Application No: LU/55/22/L
Site Address: The Flintstone Centre East Street Littlehampton BN17 6AW
Description of works: Listed building consent for the installation of 3000mm high welded mesh fencing and associated single leaf gate along a section of the northern boundary line and along the rear elevation, Ornamental fencing and associated gates to be installed, located adjacent to the existing southern side entrance to the building, as well as the installation of 3000mm high welded mesh fence encapsulating the existing boiler room to the rear of the building, demolition of existing side secondary entrance including existing ramped access and associated fittings. Repairs to the section of wall affected by the removal of the entrance.

Thank you for your internet representation made on 7th March 2022 which has been recorded as an objection with the comments as follows:

Title:
THE FLINTSTONE CENTRE
FENCING LAYOUT AS PROPOSED

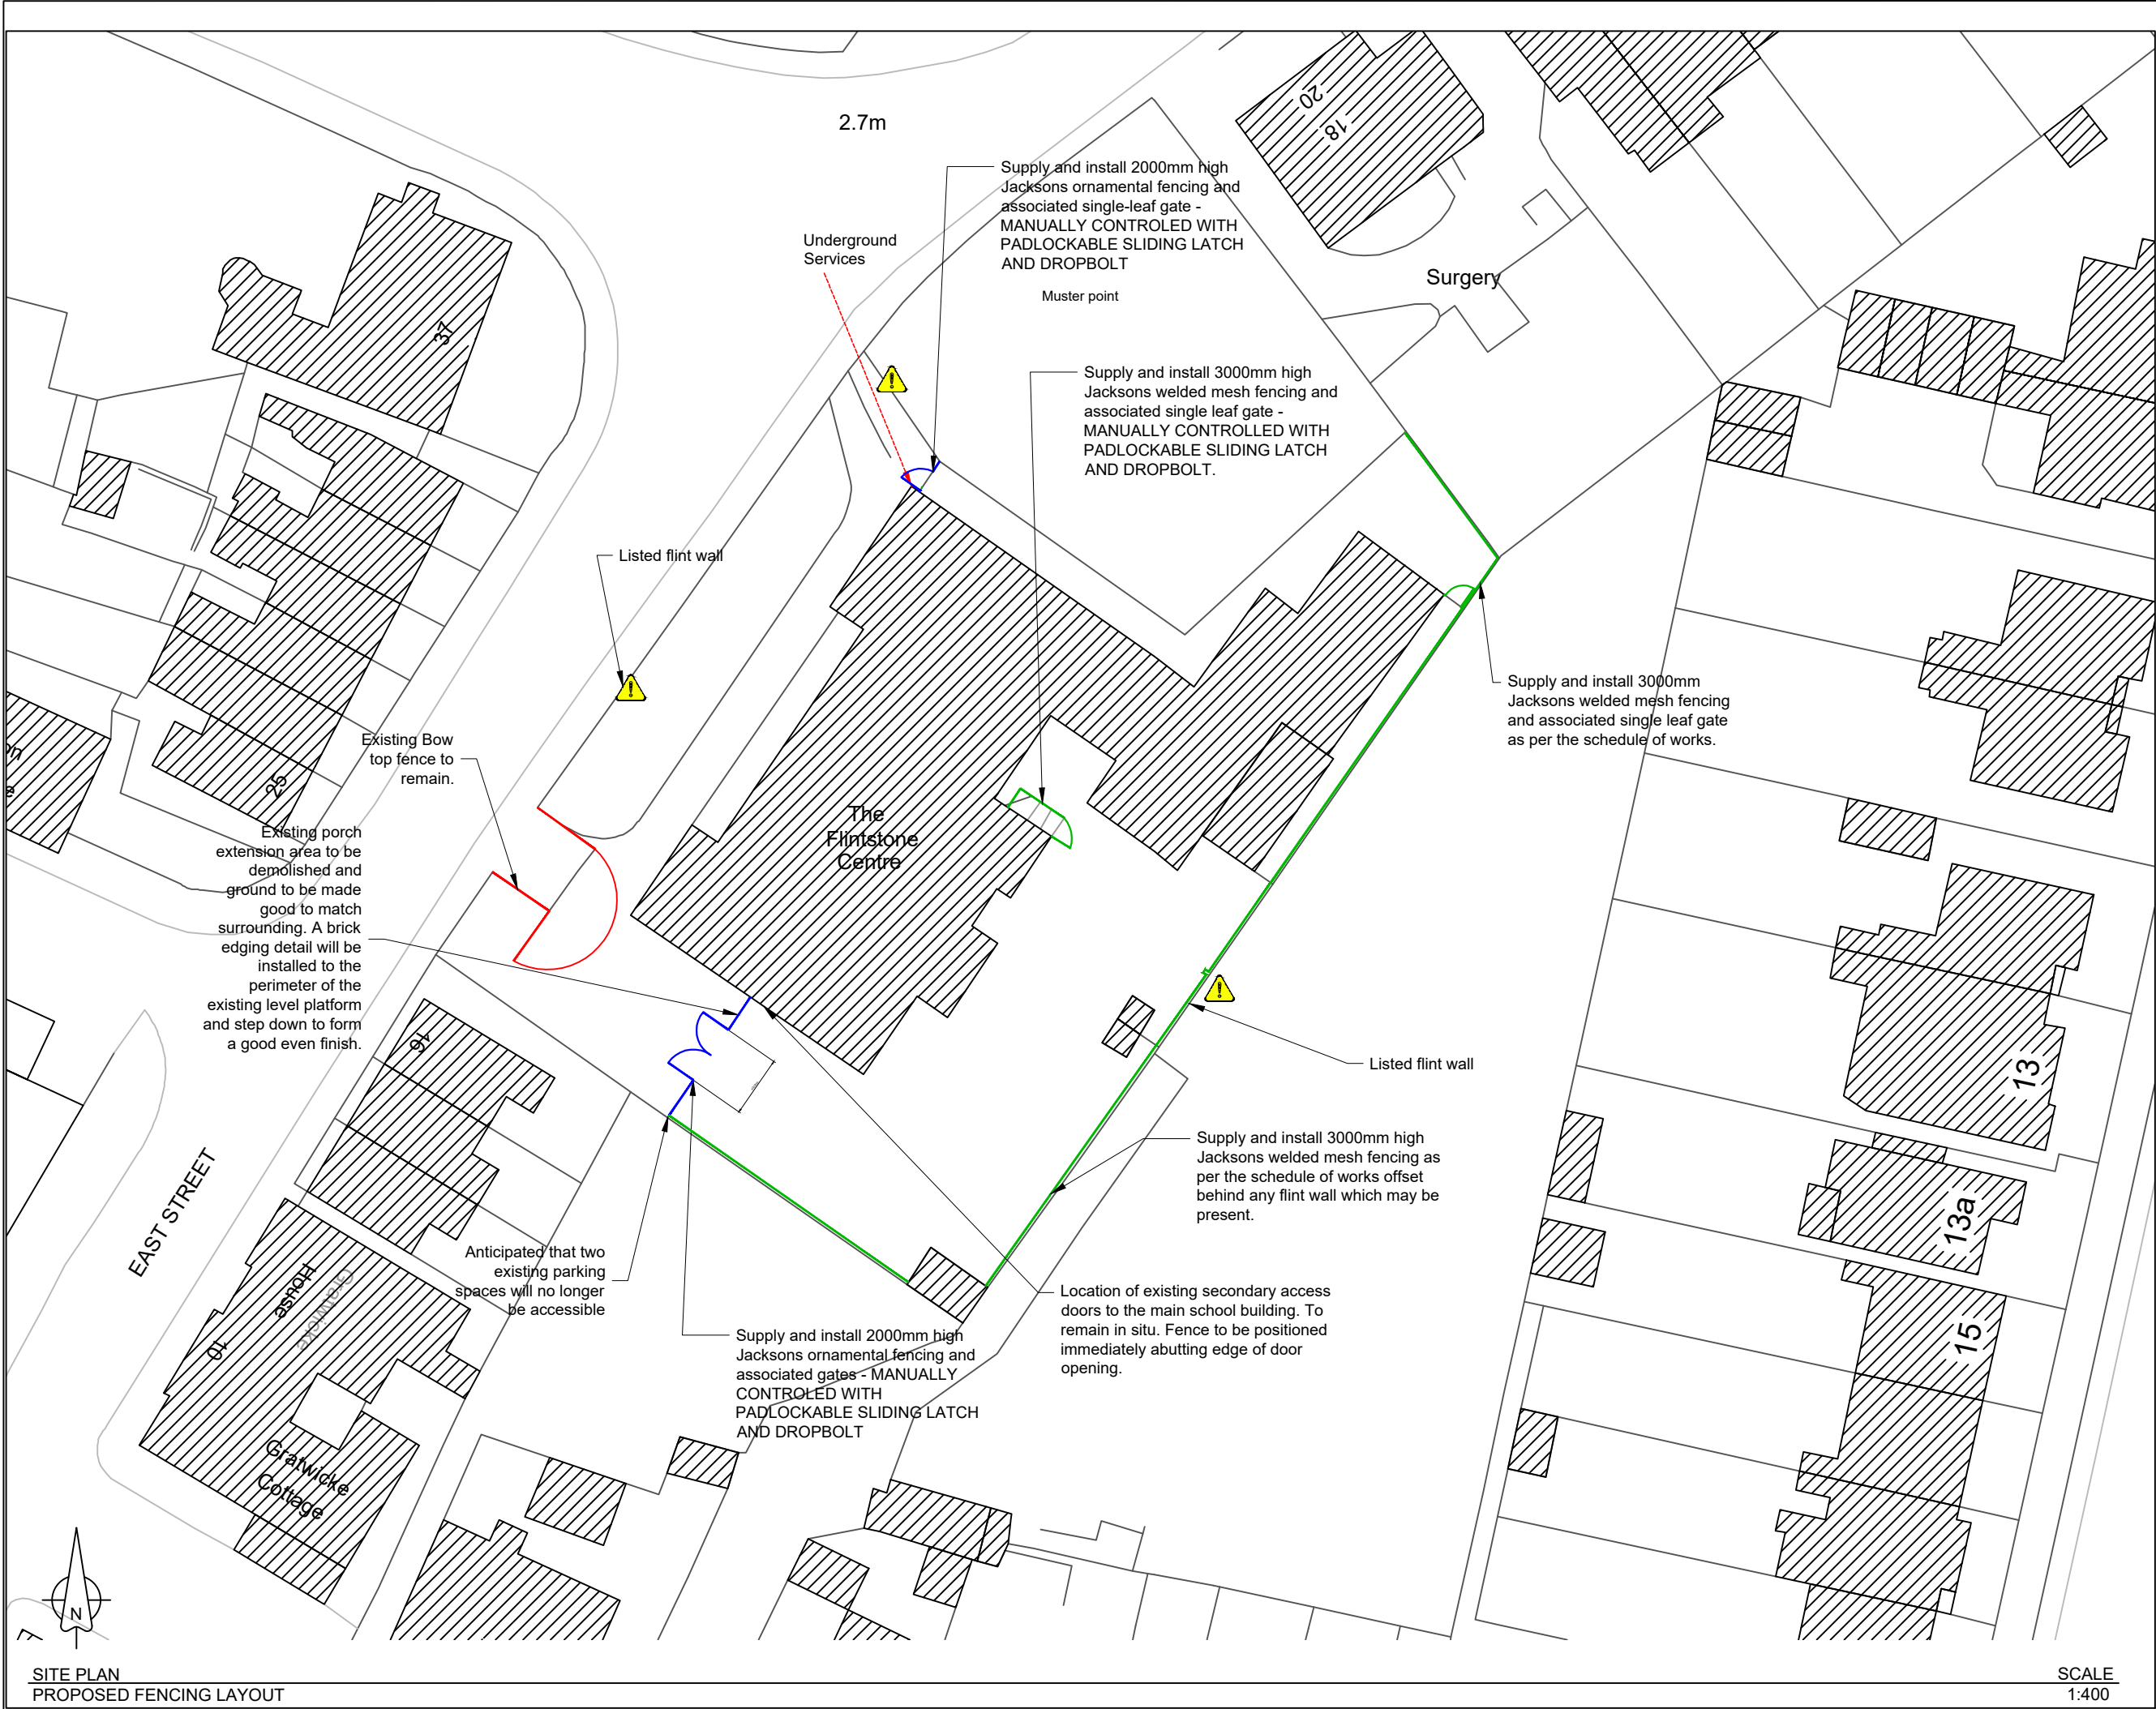
I don't think that it's suitable we have a fence erected that does not 'match' already what we have in our development. Saying this, it isn't what we was promised as residents, now it has changed. I don't believe this fence type that is planning to be put in place is good enough
Thank you
